Recommendation Report for Planning Permission for Works or Extension to a Dwelling

REF NO: M/132/17/HH

LOCATION: 1 Hadley Close  
Middleton on Sea  
PO22 6PG

PROPOSAL: Single storey rear extension to existing garage (resubmission following M/69/17/HH).

Scale 1:100  
Proposed South Rear Elevation

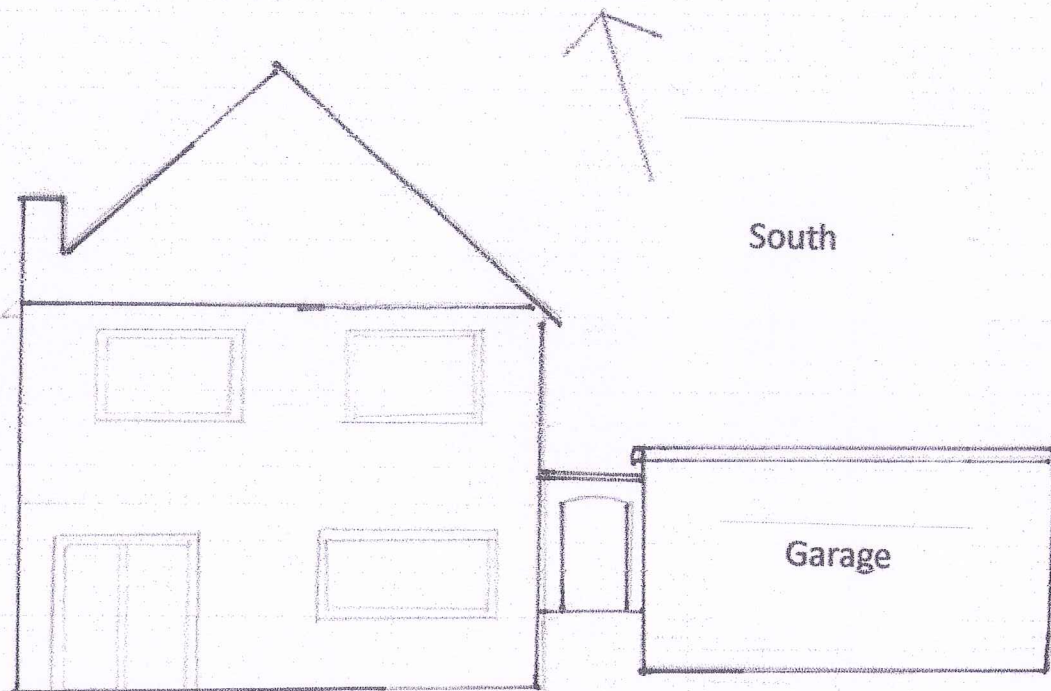
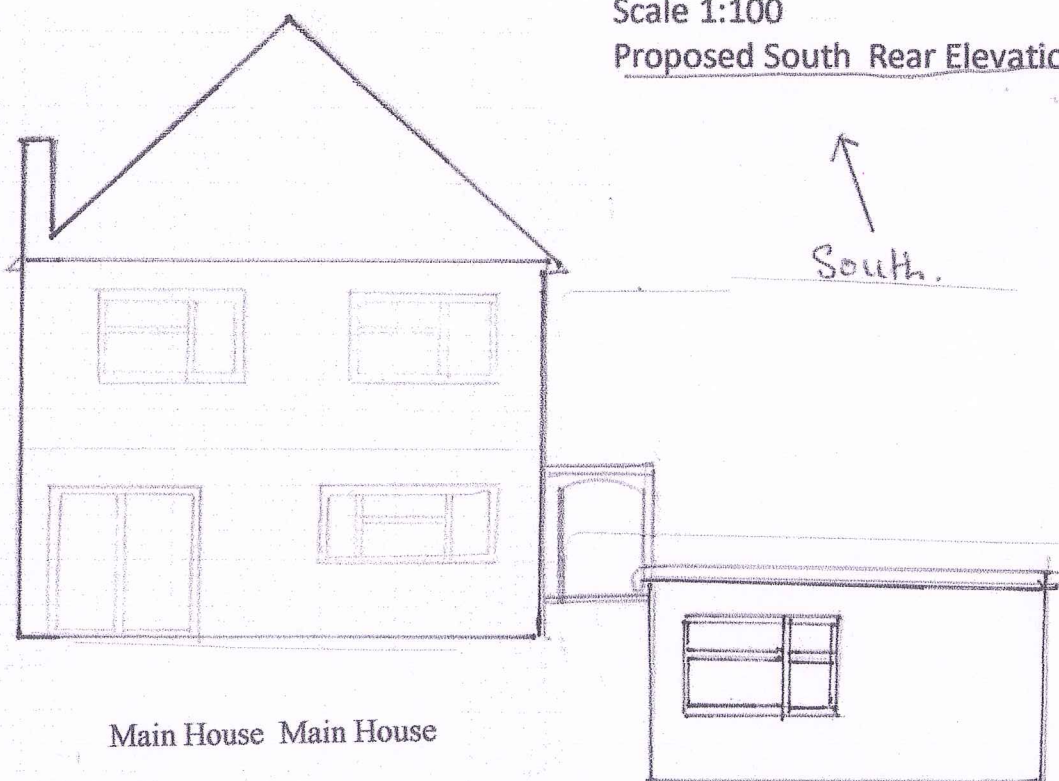
Three new windows will be installed to the western side of the proposed extension which look into the property and one window to the south. The window at the south will overlook the rear of garden. There is a separation distance of around 4m to the southern boundary line and there is also sufficient planting, whilst the distance from the proposed extension to the boundary line on the west will be around 9m. This is considered to be sufficient to prevent any adverse impacts upon neighbouring properties.

D3

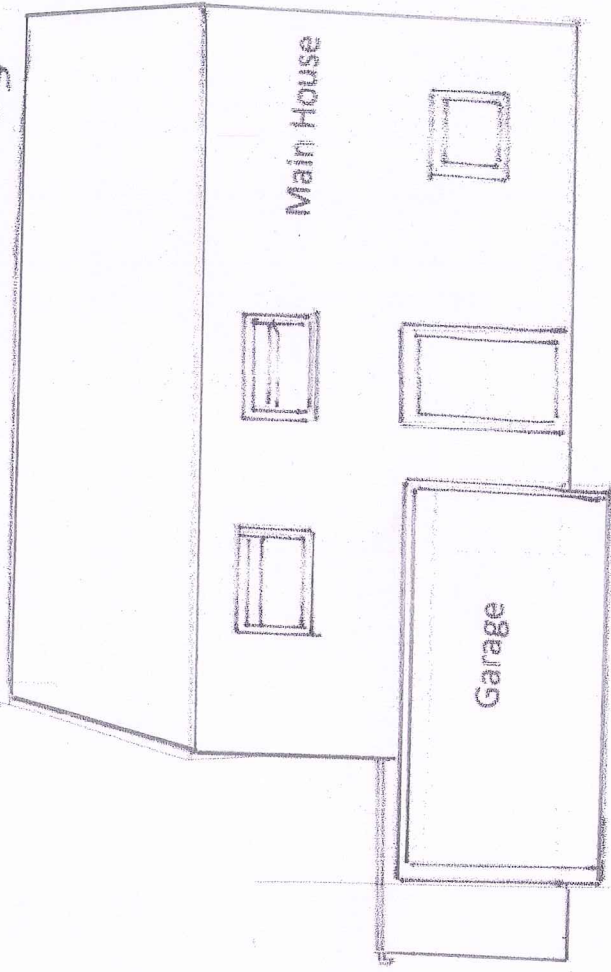
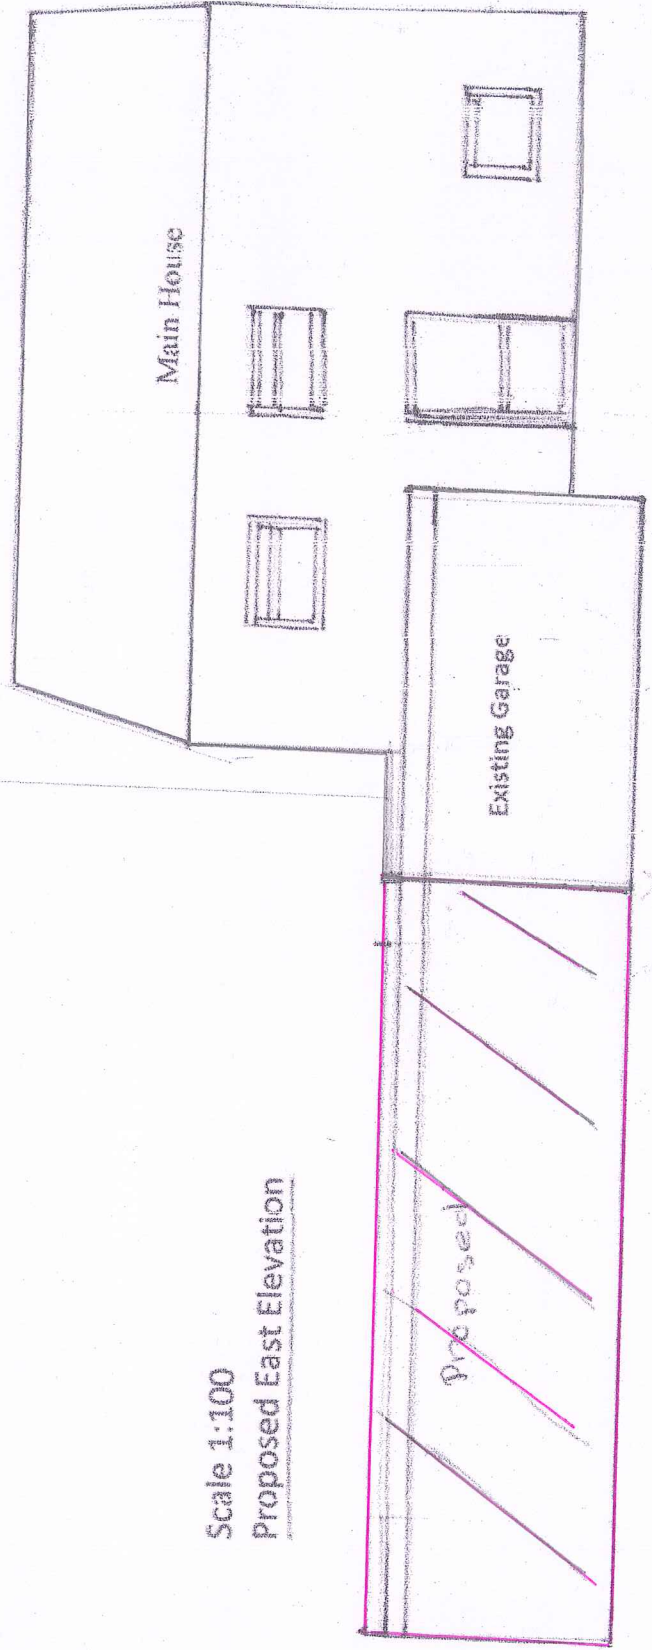
The height of the proposed extension is the same as the existing garage and sits just slightly above the fence line. Whilst the proposed extension sits quite far back into the rear garden, a reasonable sized garden area is still retained.
